# PCD PROJECT NO. PPR-16-040

STANDARD NOTES FOR EL PASO COUNTY GRADING AND EROSION CONTROL PLANS

FIGURE OS-2 TYPICAL OUTLET STRUCTURE FOR FULL SPECTRUM DETENTION
OUTLET STRUCTURES DETAILS
NOT TO SCALE

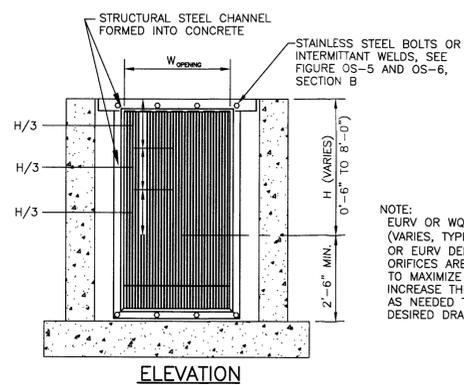
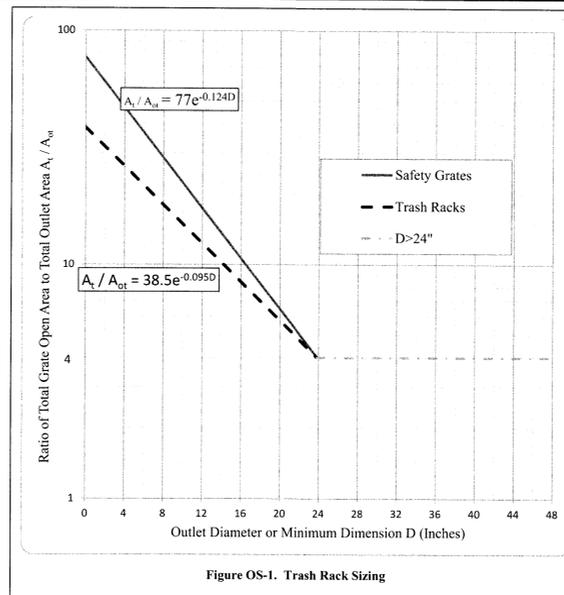
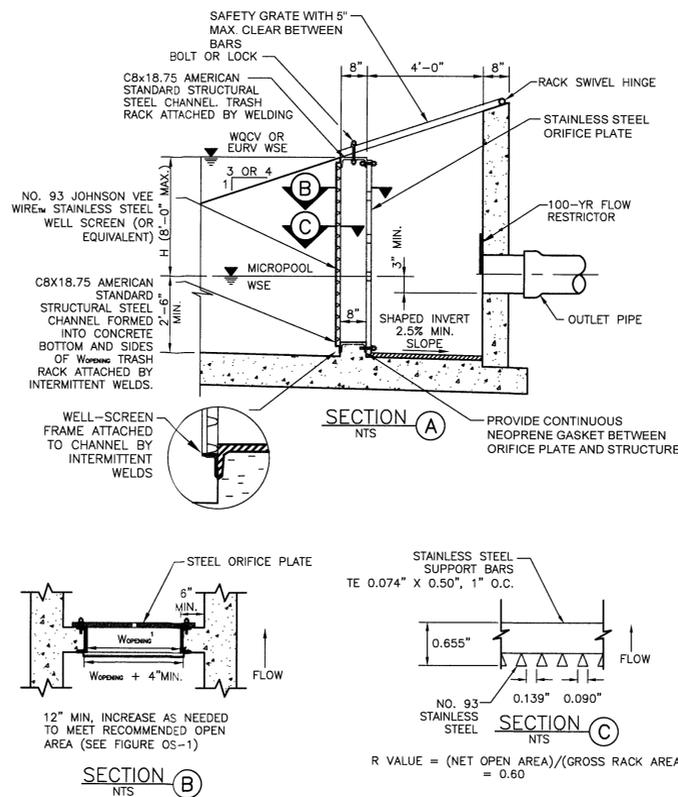
Subject: Callout Identify plate thickness on the plans. Table OS-2 Page Index: 3 is not part of the plans. Lock: Unlocked Author: dsdlaforce Date: 6/10/2019 1:57:17 PM Color: Subject: Callout Identify Forebay elevations. Sheet 2 identified the Page Index: 3 pad elevation for forebay (2), but not for forebays Lock: Unlocked (1) and (3) Author: dsdlaforce Date: 6/10/2019 2:03:03 PM Color: \_\_\_\_\_ Subject: Text Box Show the HGL. Page Index: 7 Unresolved. Lock: Unlocked Author: dsdlaforce Date: 6/10/2019 2:50:30 PM 1111 Color: \_\_\_\_\_ Subject: Polylength Measurement 1.01 ft Page Index: 7 Lock: Unlocked Author: dsdlaforce Date: 6/10/2019 2:55:03 PM Color: ..... Subject: Polylength Measurement 0.52 ft Page Index: 7 Lock: Unlocked Author: dsdlaforce Date: 6/10/2019 2:55:17 PM Color: 📕 Subject: Cloud+ Per ECM 4.3.6.A.3, When placed outside the road, Page Index: 7 at no time shall the storm sewer lines be placed Lock: Unlocked less than 1 ft in depth. Author: dsdlaforce Date: 6/10/2019 2:58:47 PM Also, consider the future storm design w/ respect Color: to the roadway. Per ECM 4.3.6.A.3. At no time shall storm sewer lines be placed less than 2 feet in depth measured perpendicularly to the finished road surface. Make sure the future phase can accommodate this criteria. ------Subject: Length Measurement (PRIVATE) 3.17 ft Page Index: 7 Lock: Unlocked TREEP 1.0% (PRIVATE Author: dsdlaforce Date: 6/10/2019 3:00:47 PM Color: Subject: Length Measurement 2.64 ft Page Index: 7 (3)38 Lock: Unlocked RCEL (PRI) Author: dsdlaforce Date: 6/10/2019 3:00:57 PM
